KITTITAS COUNTY COMMUNITY DEVELOPMENT SERVICES

RE: Suncadia Phase 1 Division 15 Preliminary Plat (LP-18-00001) – Transmittal of Comments

TO: Community Development Services
FROM: Taylor Gustafson, Environmental/Transportation Planner
DATE: May 11, 2018
SUBJECT: Suncadia Phase 1, Division 15 LP-18-00001

**NEW SUNCADIA LLC**  
**PHASE 1 DIVISION 15**  
 COMPOSITE UTILITY PLAN

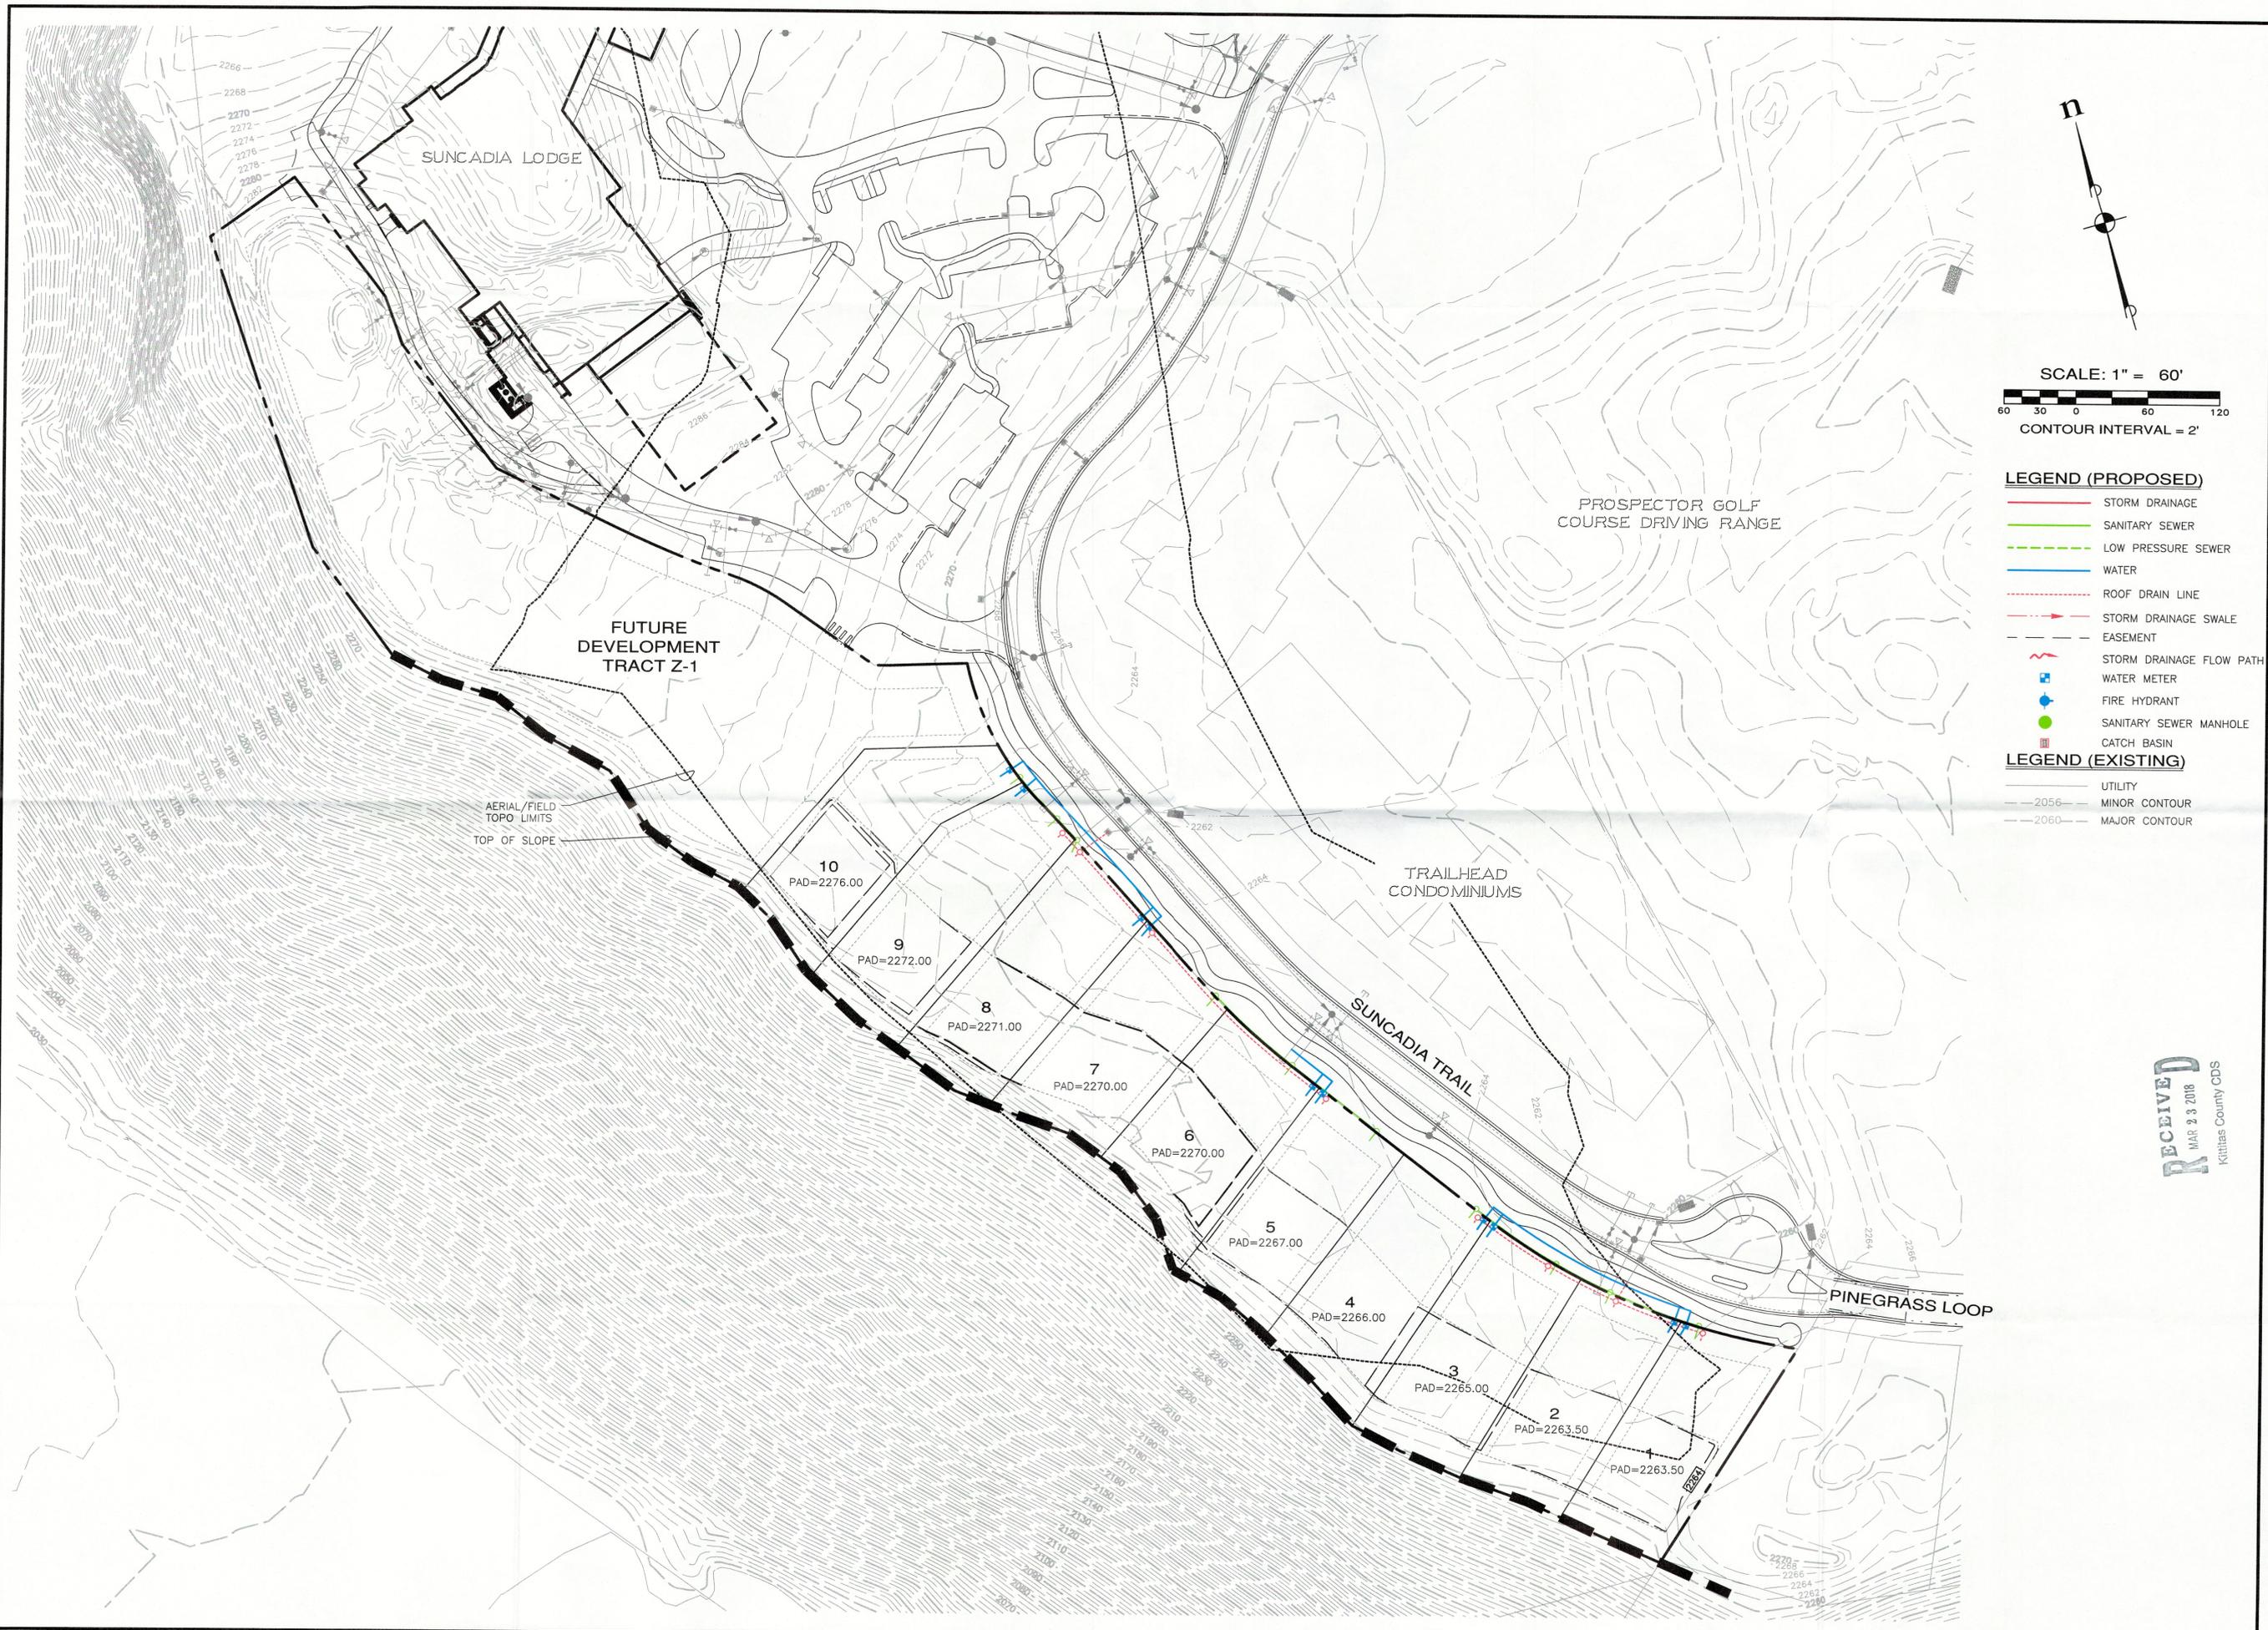
The State of Washington Department of Health (DOH) Office of Drinking Water (ODW) seeks confirmation of the following, from Suncadia regarding these 10 new homes:

- These new homes are identified in the currently approved Water System Plan for Suncadia.
- Either of the following: (a) the existing water system has capacity to serve these new connections, or (b) a specific Capital Improvement Project, identified in the currently approved Water System Plan, will be completed as part of the construction of these homes.

NEW SUNCADIA LLC
SUNCADIA PHASE 1 DIVISION 15
PRELIMINARY PLAT
KITTITAS COUNTY WASHINGTON

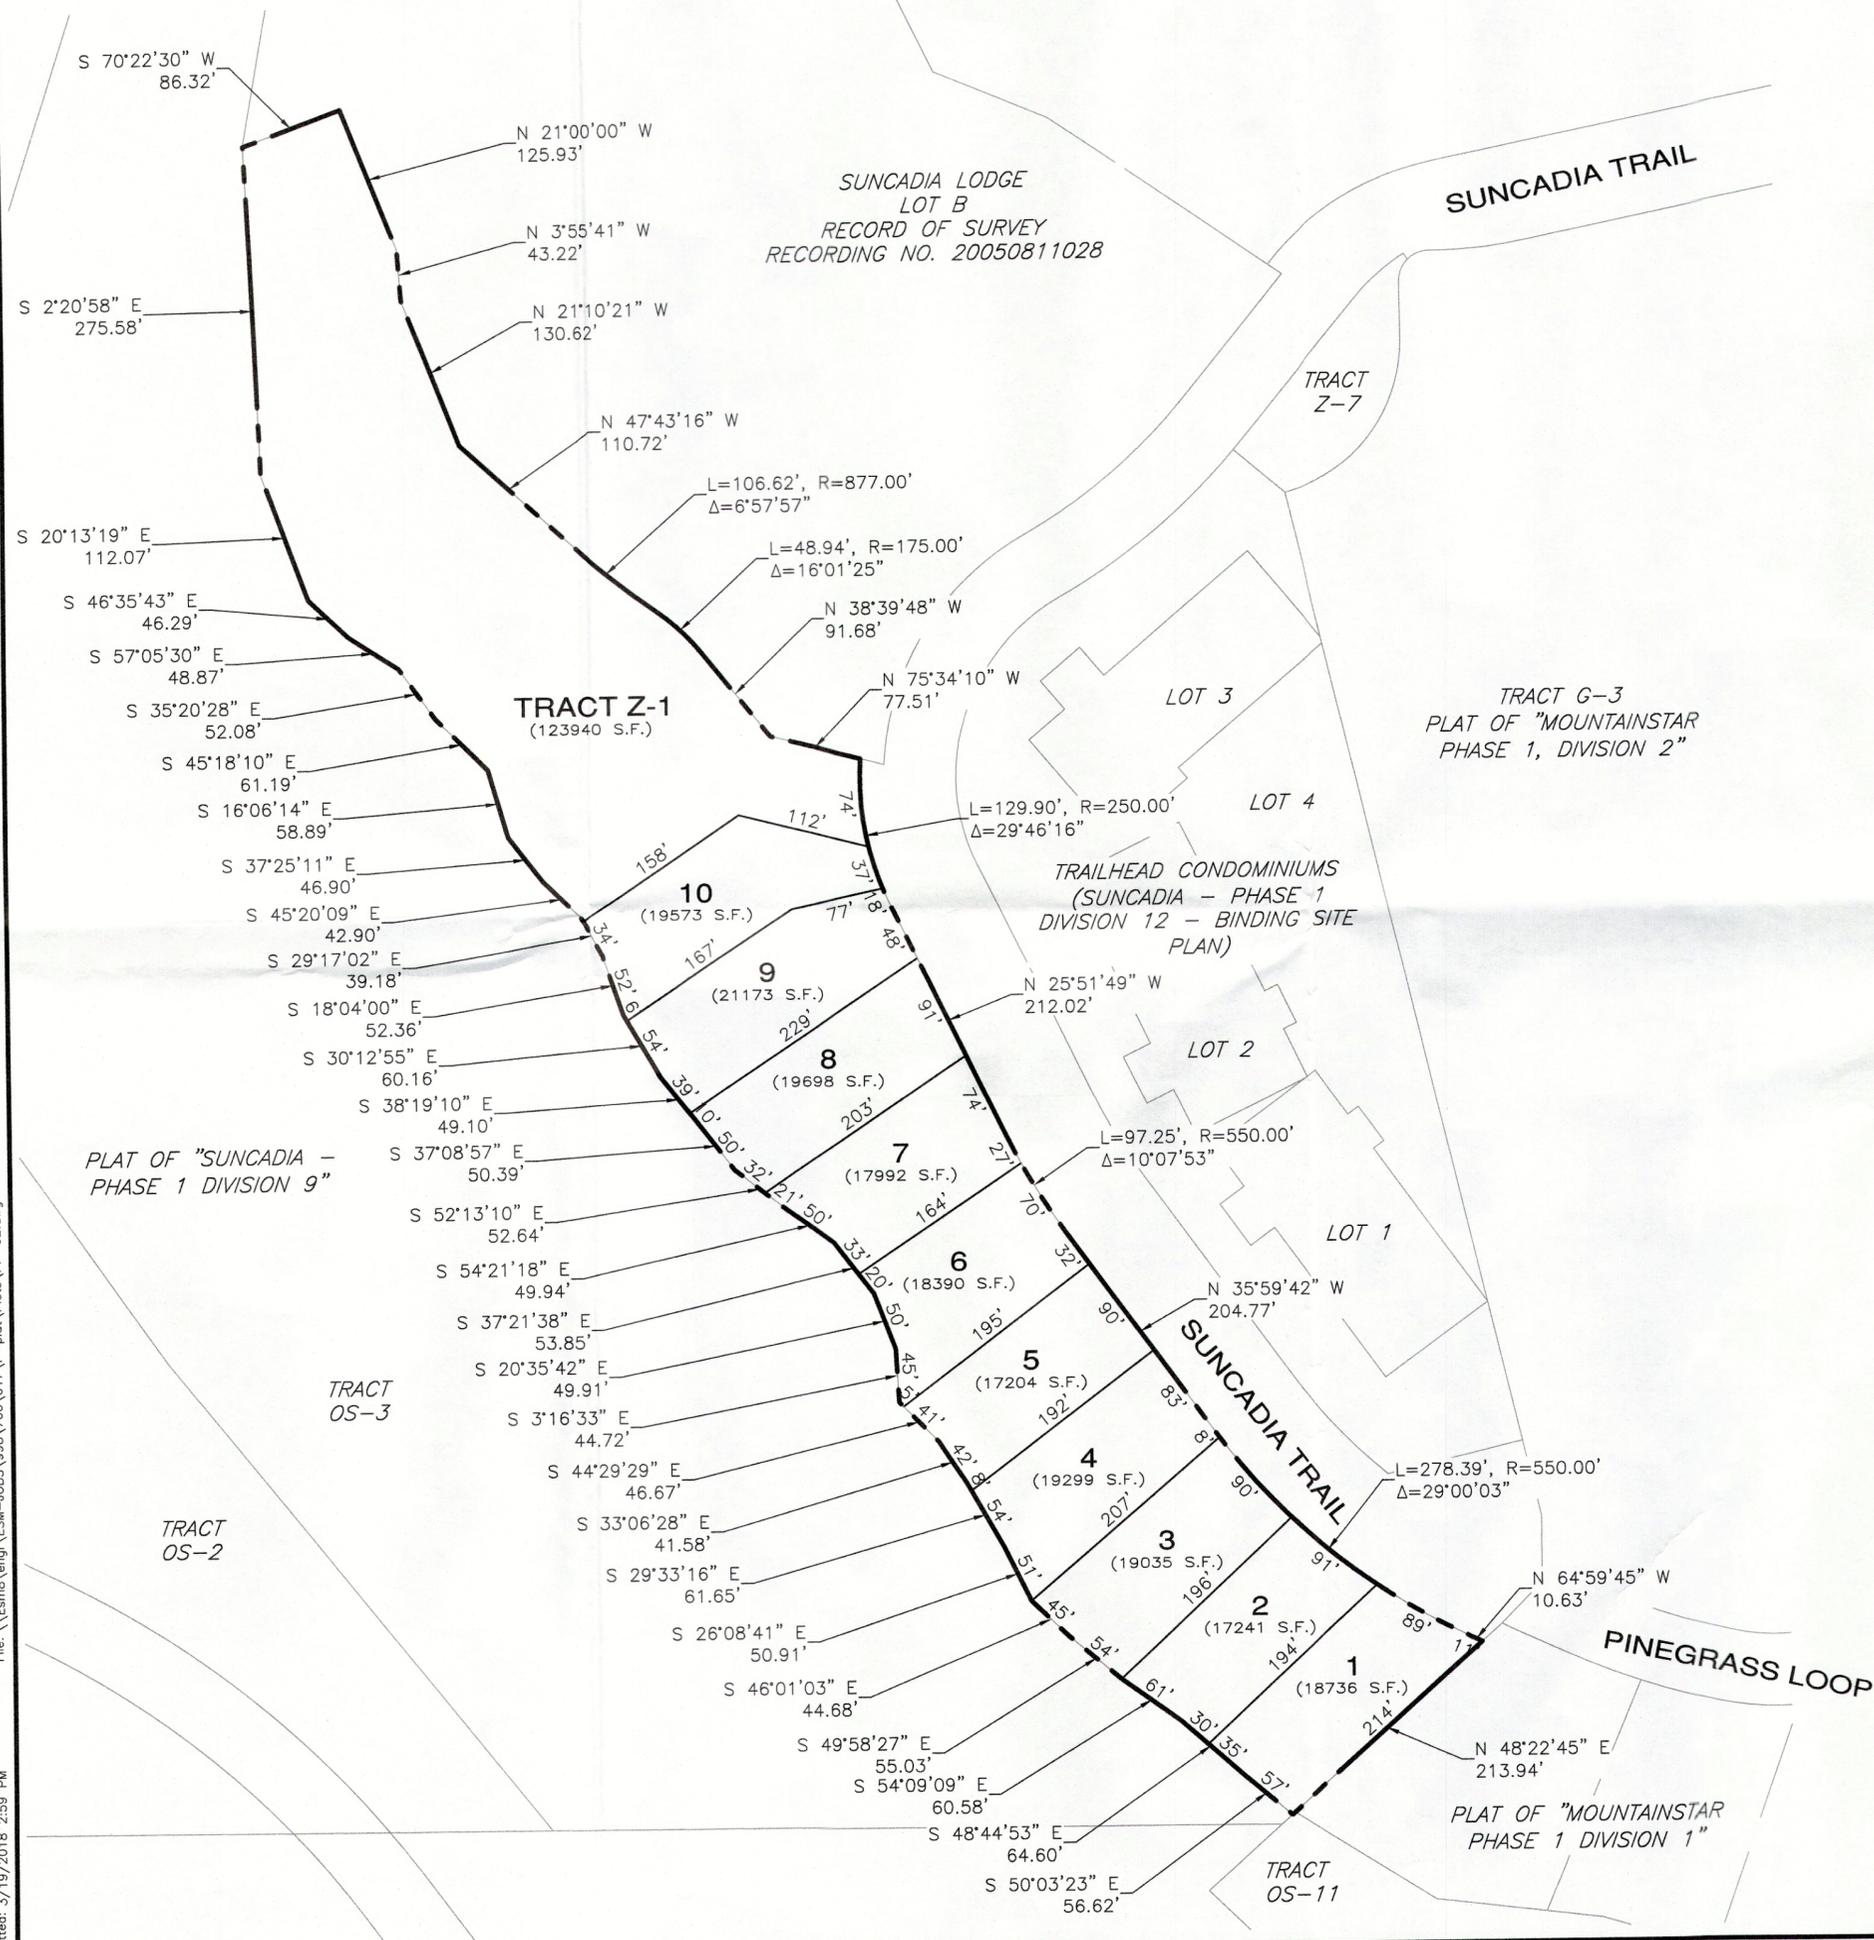
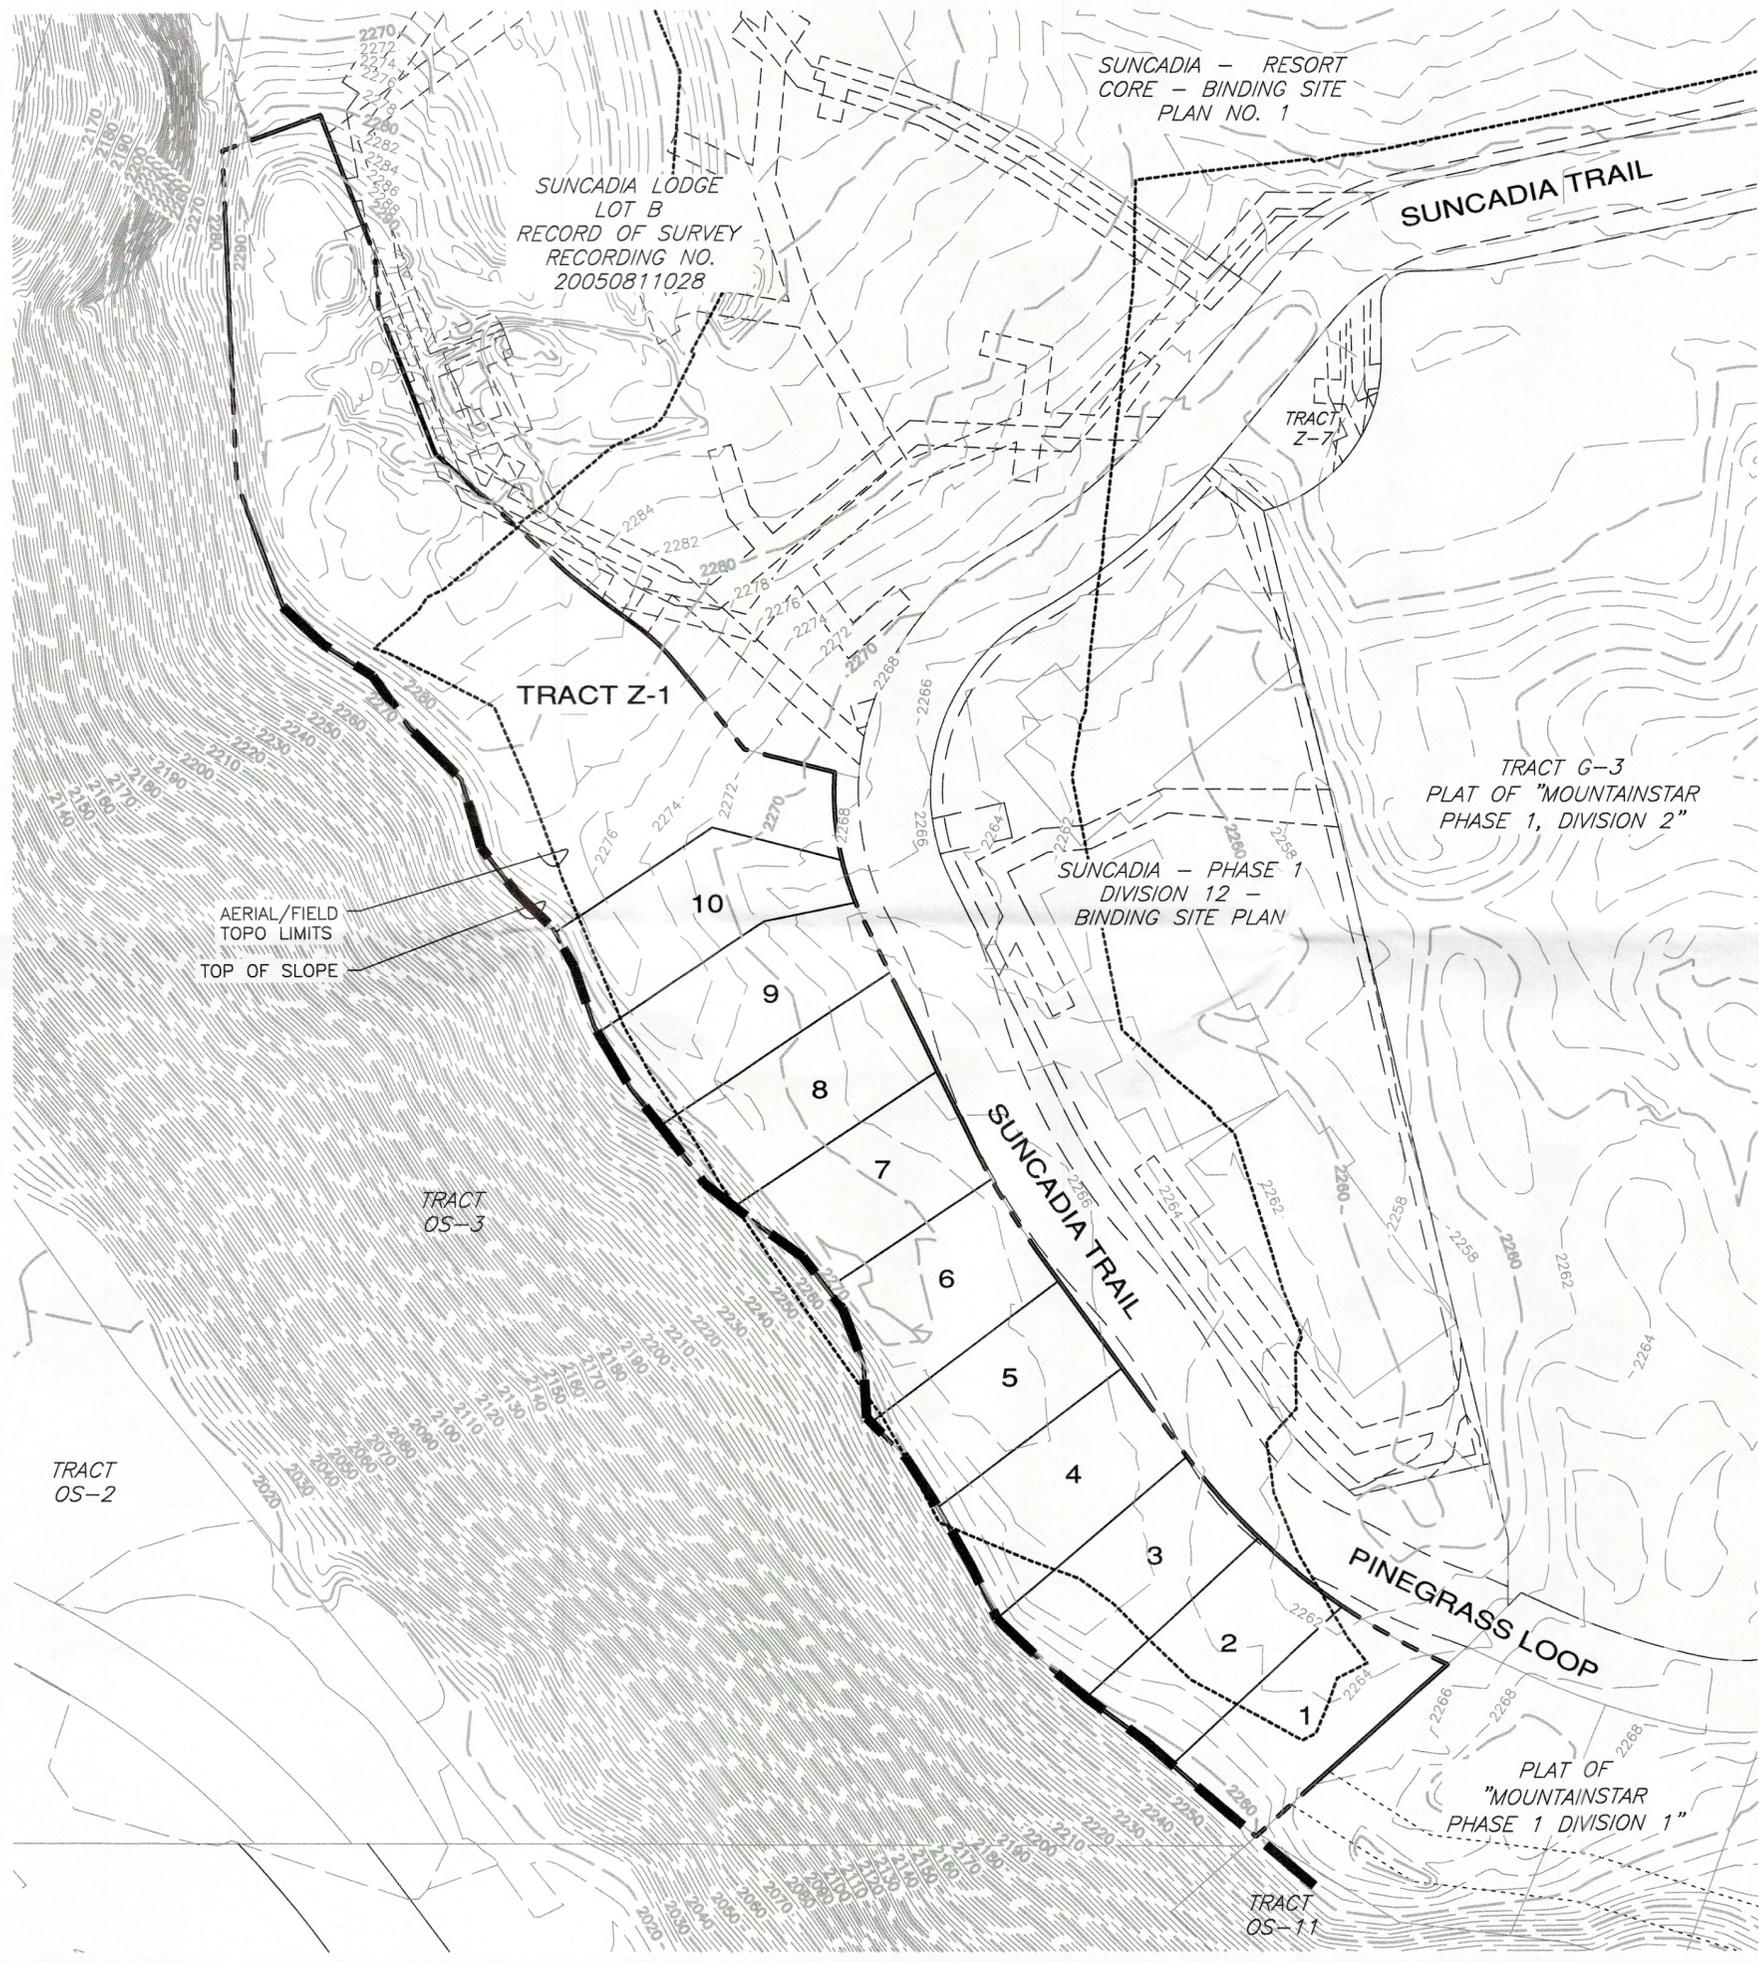
1. The submitted Preliminary Plat does not contain the name of the Surveyor/Engineer responsible for preparing the documents.(KCC 16.12.020(5))
2. Roadways should show name, width, and type (private roadway-paved). (KCC 16.12.030(2)).
